April 20, 2022

**RE: Moran Development**

This letter includes our responses to comments received from Pierce County regarding the Swanson Development project on January 11, 2022. We have reviewed and revised the plan set and associated reports/documents to reflect the changes requested.

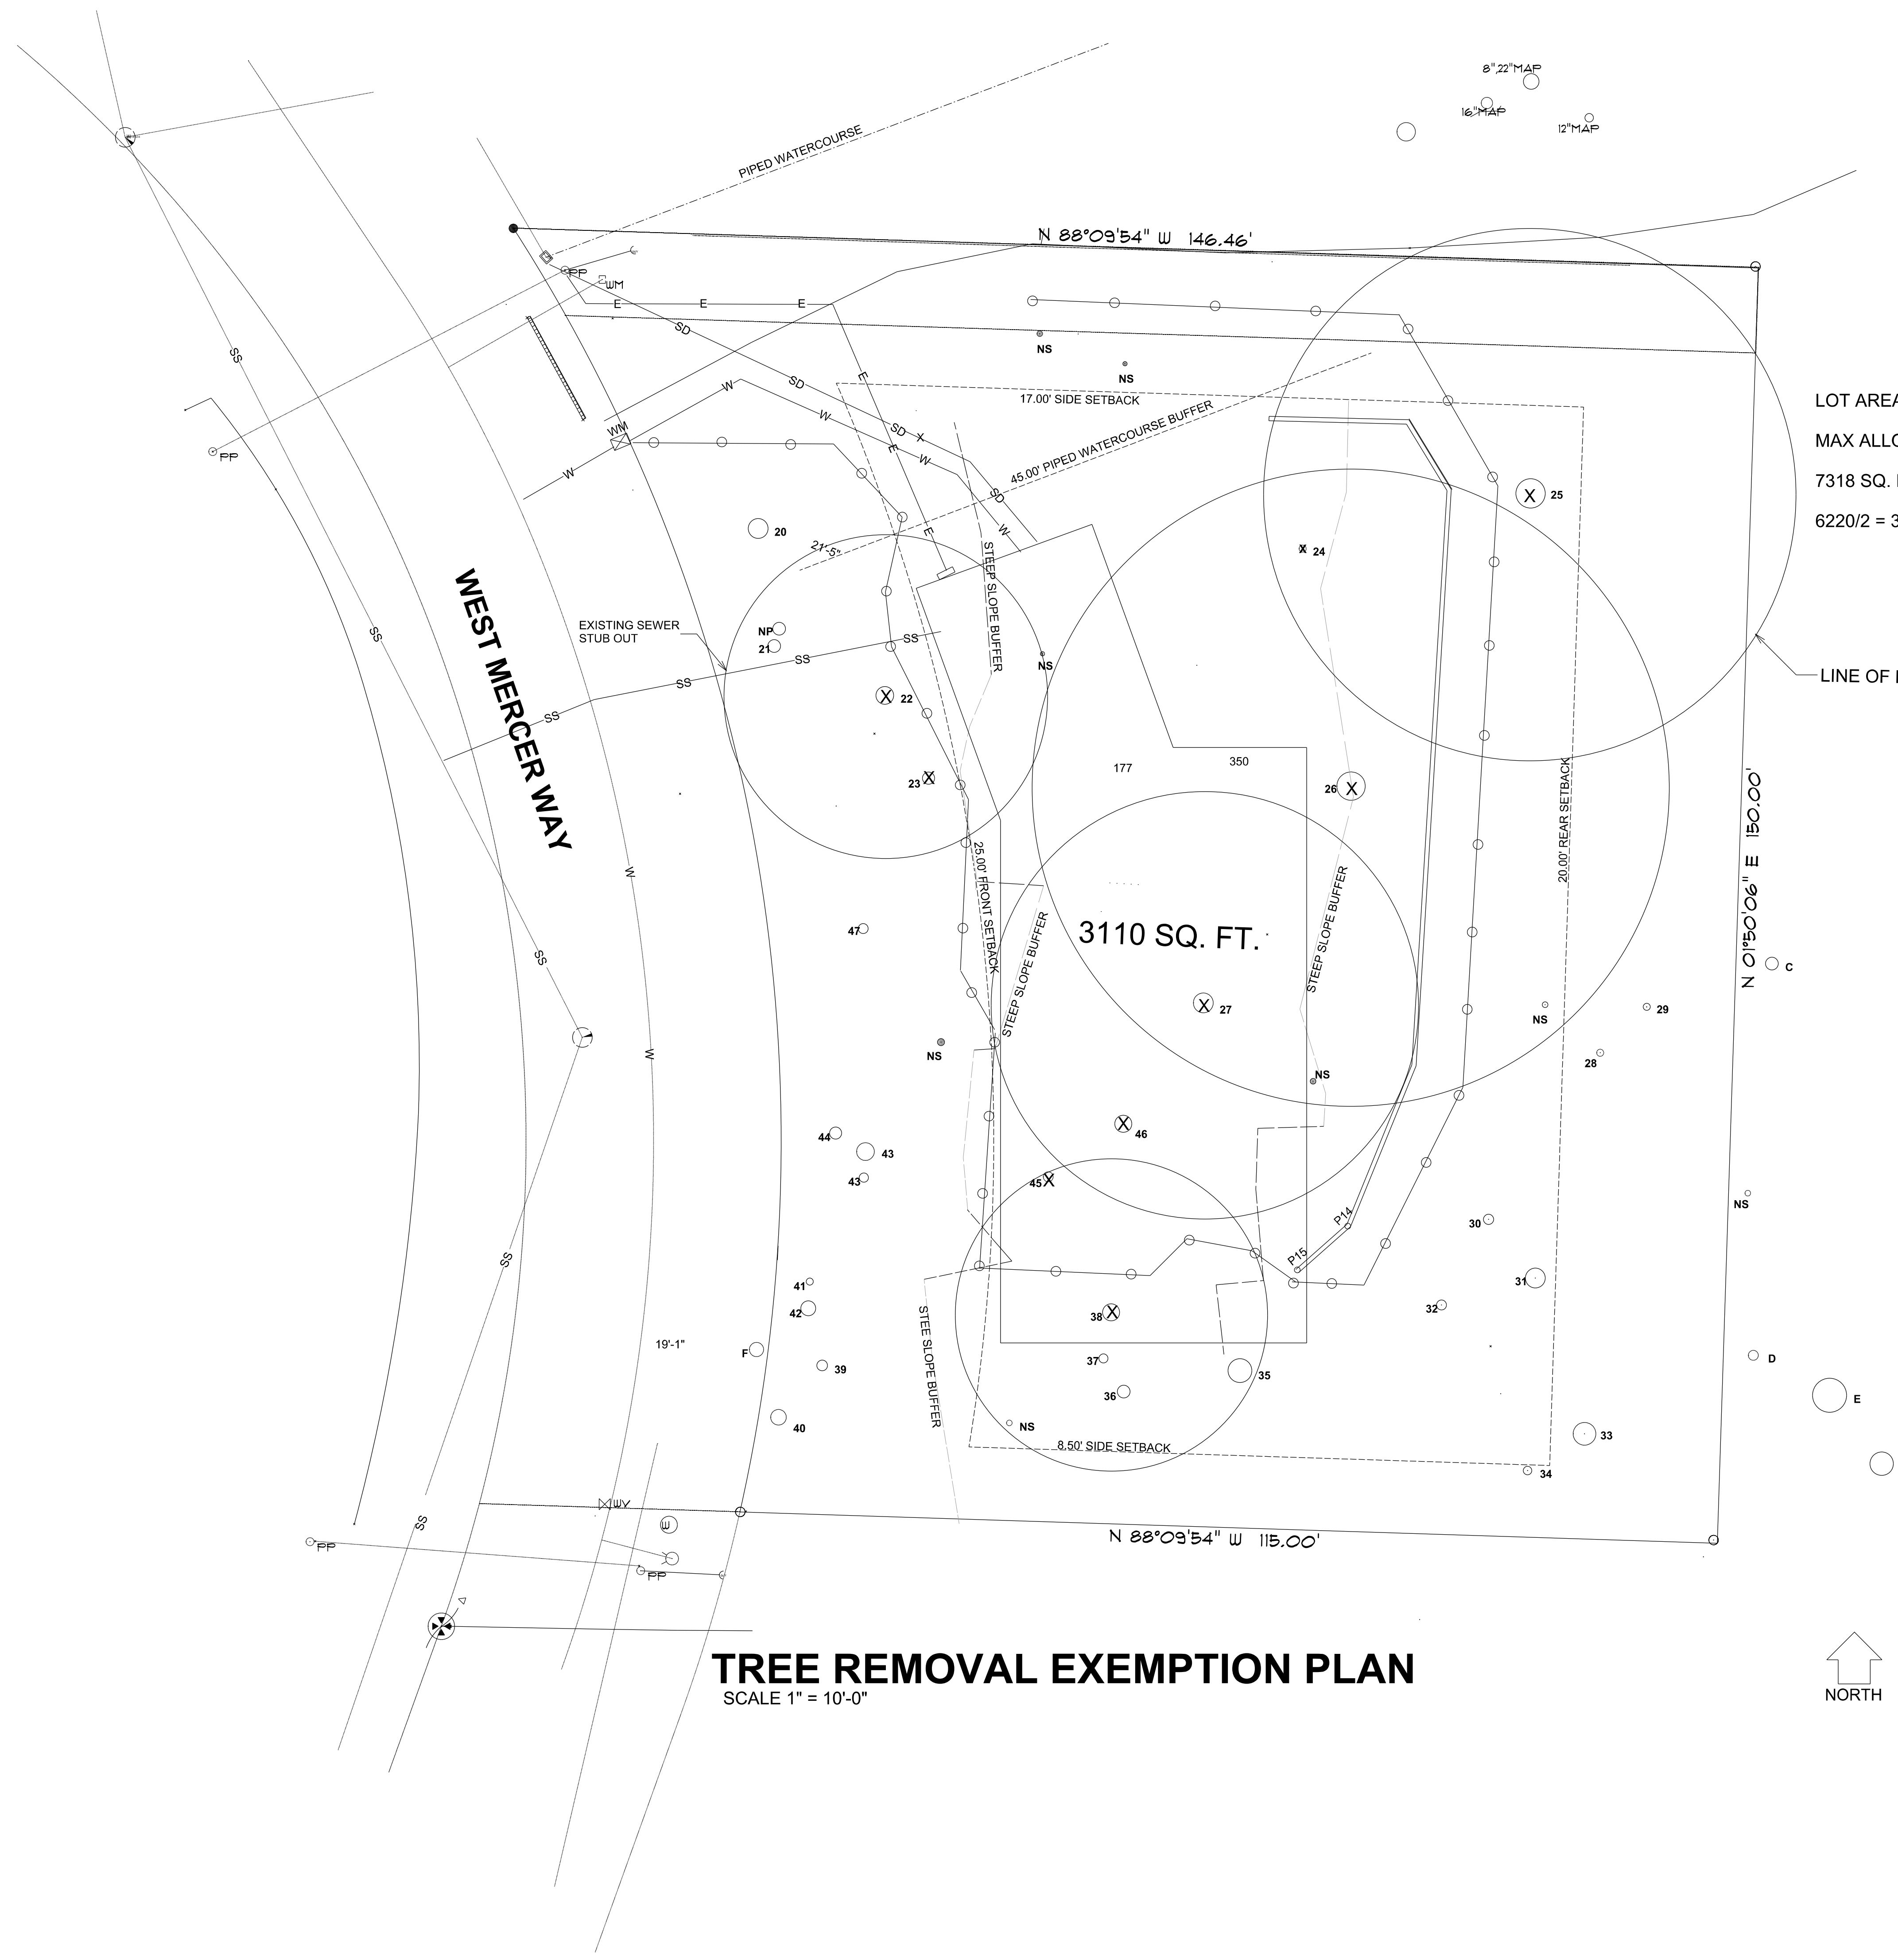
5. MICC 19.02.020(C)(1)(c)(i)((b)) states that for lots with a width of more than 90 feet, the sum of the side yards' width shall be a width that is equal to at least 17% of the lot width. This lot is 150 feet in width, so the widths of the side yards must add up to 25.5 feet, with a minimum width of 8.5 feet. Please revise the side yard widths shown on the site plan accordingly.

Response: Noted, site plan has been revised to show side yard widths.
